# Response to An Bord Pleanála Opinion

42A Parkgate St.  
Dublin 8

Mixed Use, Residential &  
Commercial Development  
ABP - SHD Application\_  
Project Ref: P18-107D

Proposed Ground Floor Plan
 1 : 200

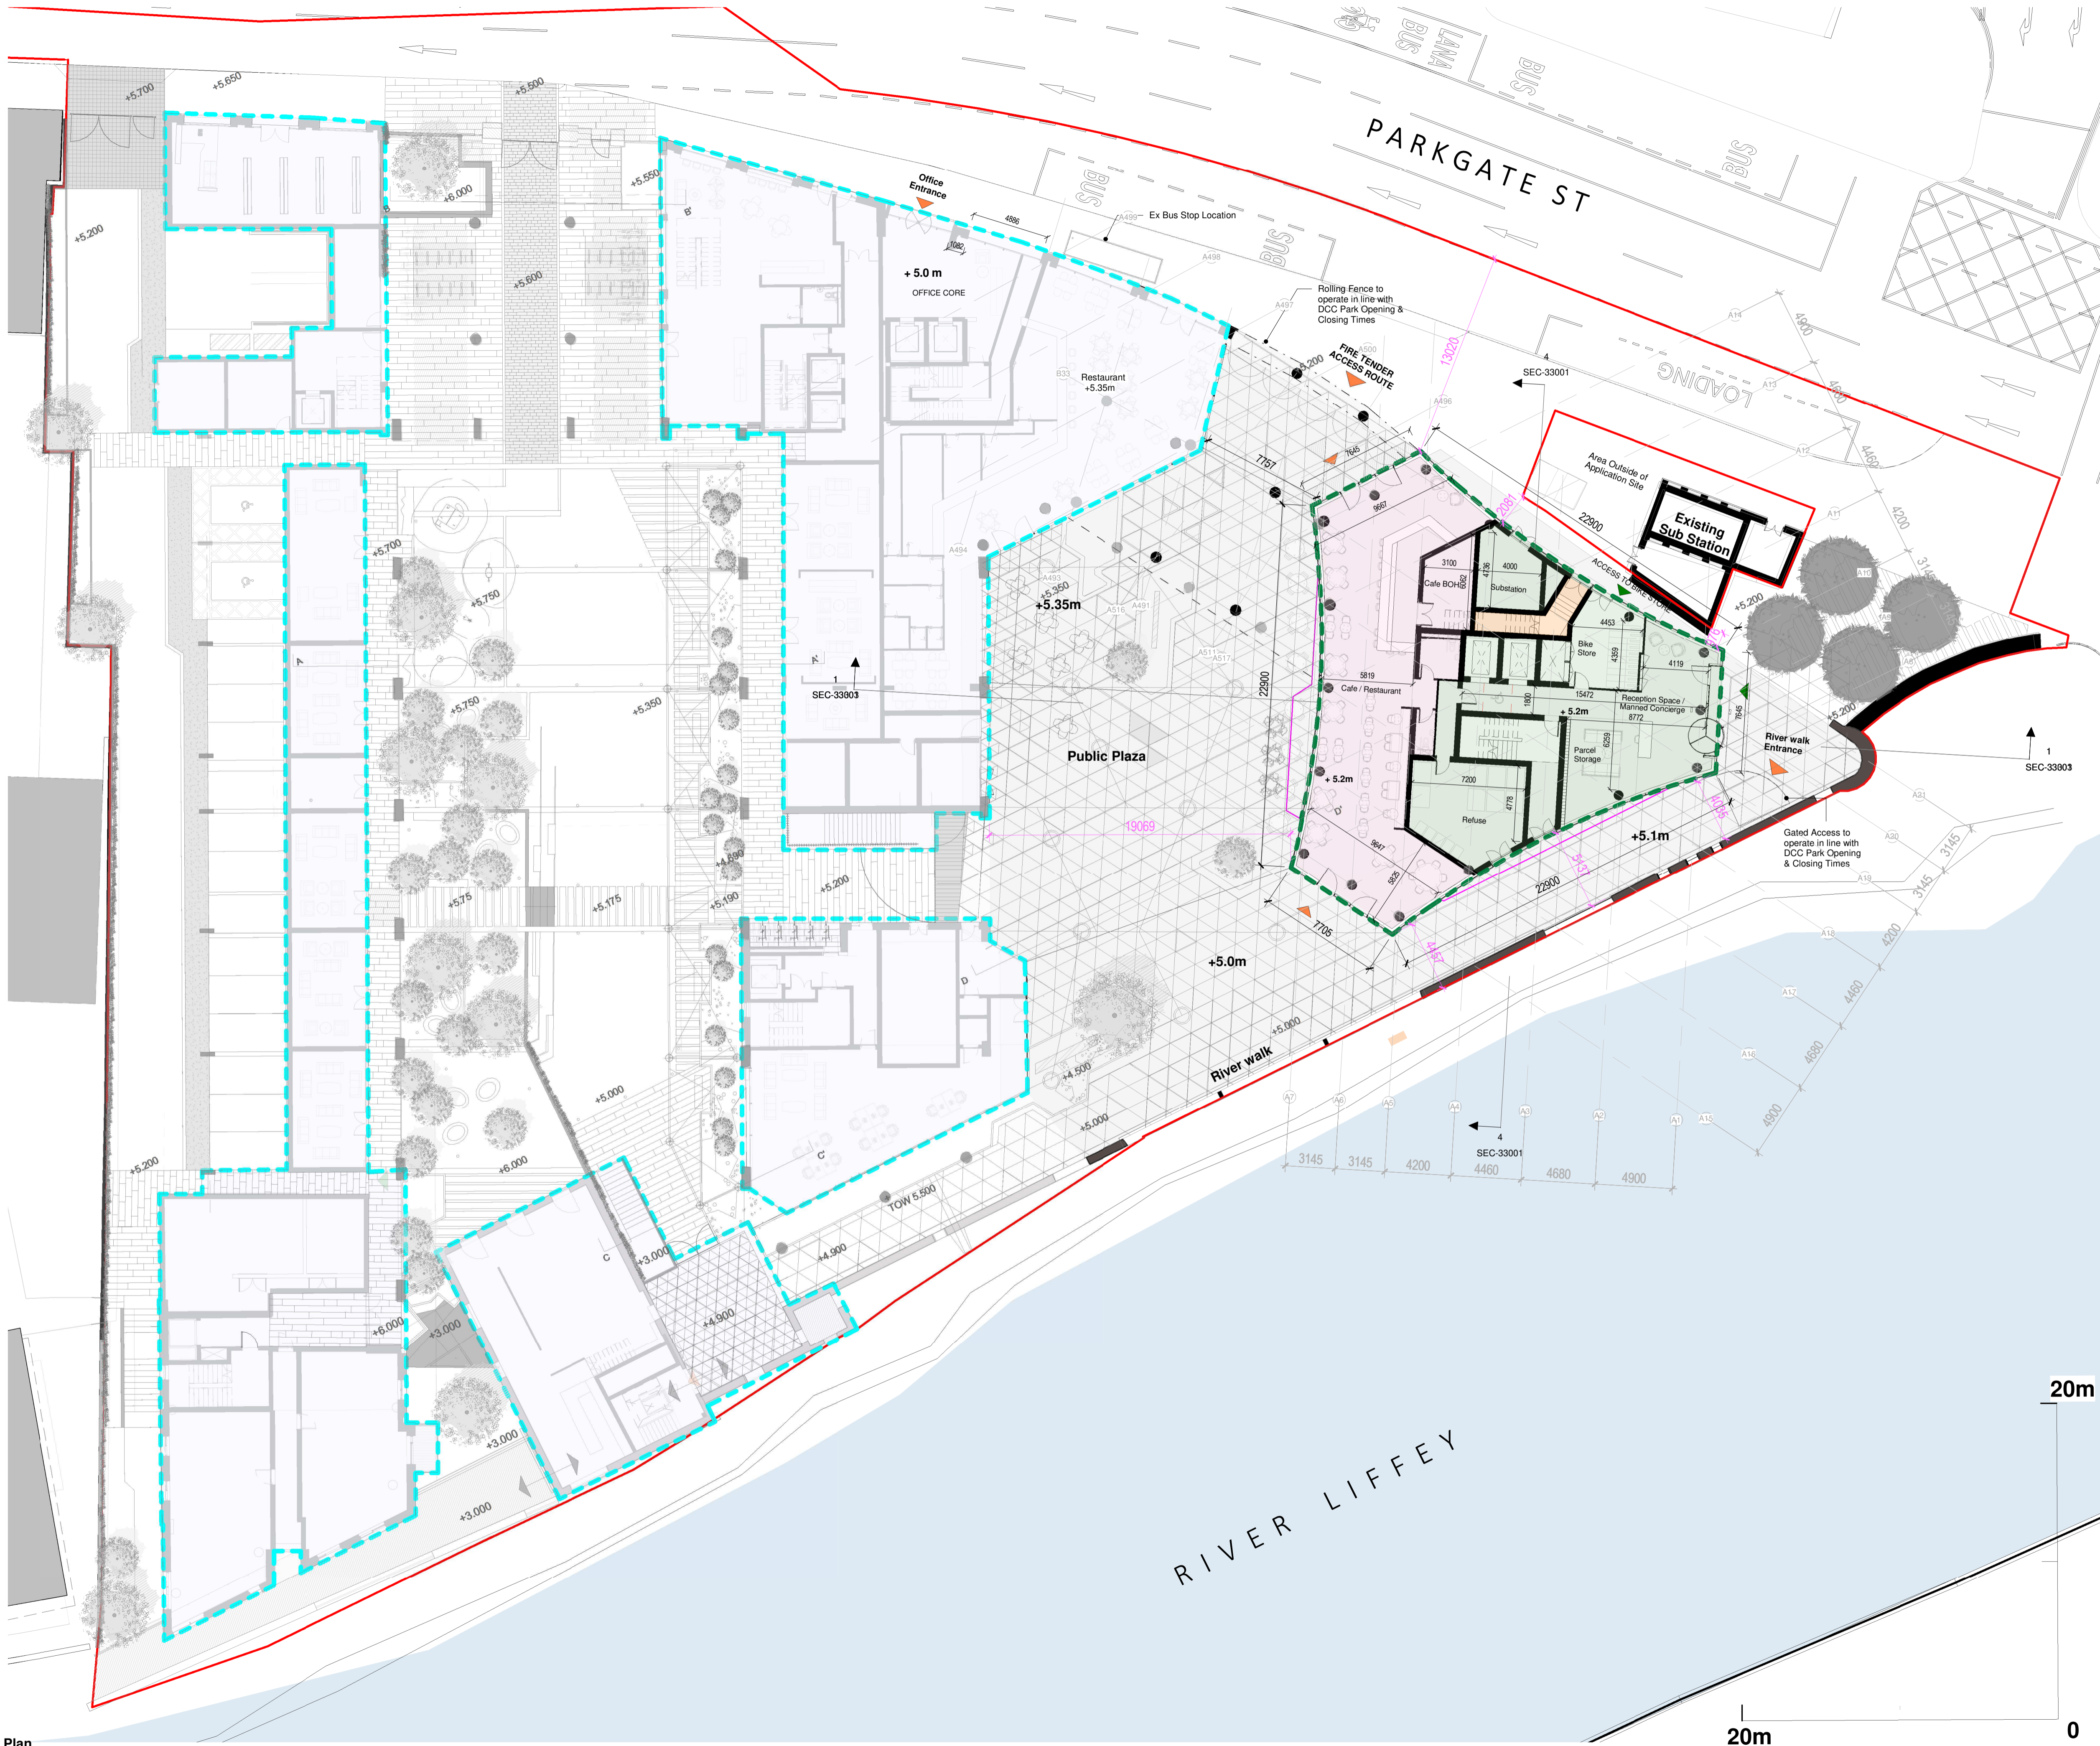
2. The submitted Ground Floor Plan incorrectly shows outward opening doors onto Parkgate Street as part of permitted scheme under reg. ref. SHD0001/20 (ABP Ref. 306569-20). The design of the entrance to the public open space varies between the various submitted layout drawings. The applicant should ensure that the permitted scheme is accurately detailed as part of the overall site layout submission, unless where changes are proposed and that any proposed changes are clearly noted.

The outward opening doors on the ground floor of the tower have been adjusted to inward opening as was consented previously. Please refer to the Architectural Drawings.
